STATE OF NORTH CAROLINA
DEPARTMENT OF TRANSPORTATION

Subject: **Application for Modification to Section 404 Nationwide Permits 23 and 13, Section 401 Water Quality Certification, and Neuse Riparian Buffer Authorization** for the replacement of Bridge No. 143 over Beaverdam Creek on SR 2217 (Old Milburnie Road), Wake County. Federal Aid Project Number BRZ-2217(1), WBS No. 33641.1.1, State Project No. 8.2409501, Division 5, T.I.P No. B-4304.

The purpose of this submittal is to request a modification to the Section 404 permit, Section 401 Water Quality Certification, and Neuse Riparian Buffer Authorization for B-4304. Please see the enclosed copies of the revised permit drawing sheets 6 and 7 of 9, revised Neuse Buffer impact drawing sheet 7 of 7, and revised summary tables for the above-referenced project.

Buffer Drawing
 Sheet 7 of 7

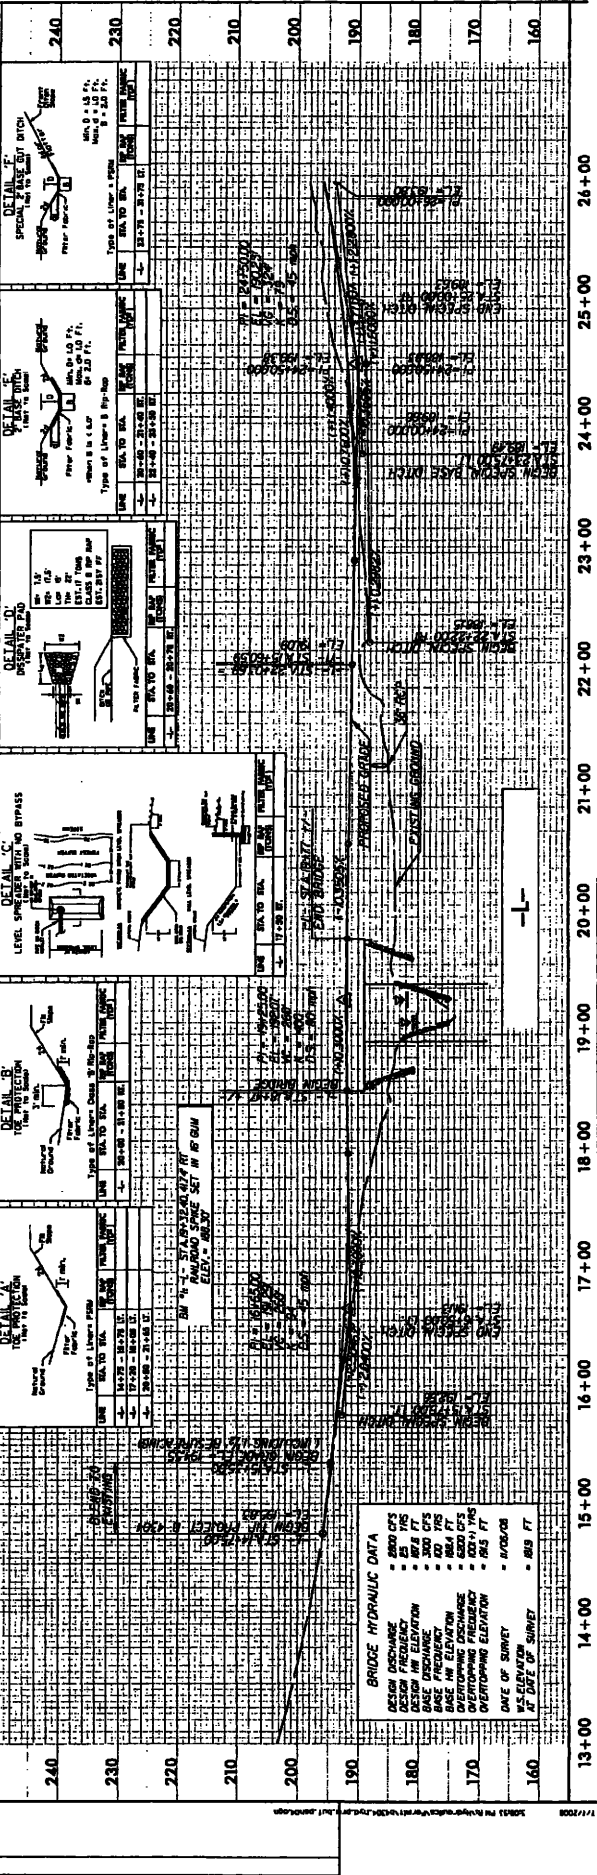
Permit drawings have been revised to depict rip rap on natural ground at inlet and outlet of the equalizer pipe. Installation of the rip rap will require excavation in wetland. Accordingly, these impacts on Stream/Wetland Permit Drawings have been revised from mechanized clearing in wetland to excavation in wetland at the rip rap. The original permit drawings (Stream/Wetland Permit Drawing Sheets 6 and 7 of 9 and Buffer Permit Drawing Sheet 7 of 7) depict no rip rap at the inlet or outlet of the pipe.

The original permit drawings (Stream/Wetland Permit Drawing Sheets 6 and 7 of 9 and Buffer Permit Drawing Sheet 7 of 7) depict a 36 inch pipe structure that will be collared and extended. A recent recalculation of impacts indicates that an additional 10 linear feet of permanent existing perennial stream impacts may be necessary for bank stabilization activities associated with the pipe extension. The original Stream/Wetland Permit Drawing Sheets 6 and 7 of 9 only indicate a mechanized clearing impact at this pipe structure. Extension and collaring of the pipe structure will instead require excavation in wetland. Permit drawings have been revised to depict wetland excavation (<0.01 acres) in lieu of mechanized clearing at the 36 inch pipe structure.

The original Buffer Permit Drawing Sheet 7 of 7 did not accurately depict the footprint necessary to construct the project at this location. The buffer permit drawing has been revised to cover the anticipated construction activities and the outer boundary of buffer impact is now consistent with the outer boundary of wetland impact. This results in an increase in Neuse buffer impact (Road Crossing: Exempt) of 598 square feet in Zone 1 (897 square feet in original permit) and 209 square feet in Zone 2 (604 square feet in original permit) compared to the original permit (Table 1).

Permit drawings have been revised to depict a level spreader with a Class B rip rap-lined forebay. The original permit drawings (Stream/Wetland Permit Drawing Sheets 6 and 7 of 9 and Buffer Permit Drawing Sheet 7 of 7) depict a level spreader with no forebay.

The original permit drawings (Stream/Wetland Permit Drawing Sheets 6 and 7 of 9 and Buffer Permit Drawing Sheet 7 of 7) depict the special 2-foot base cut ditch with a liner of permanent soil matting and rock check dams. It was determined that the rock check dams are not required. The Permit drawings have been revised to delete the rock check dams in the special 2-foot base cut ditch.
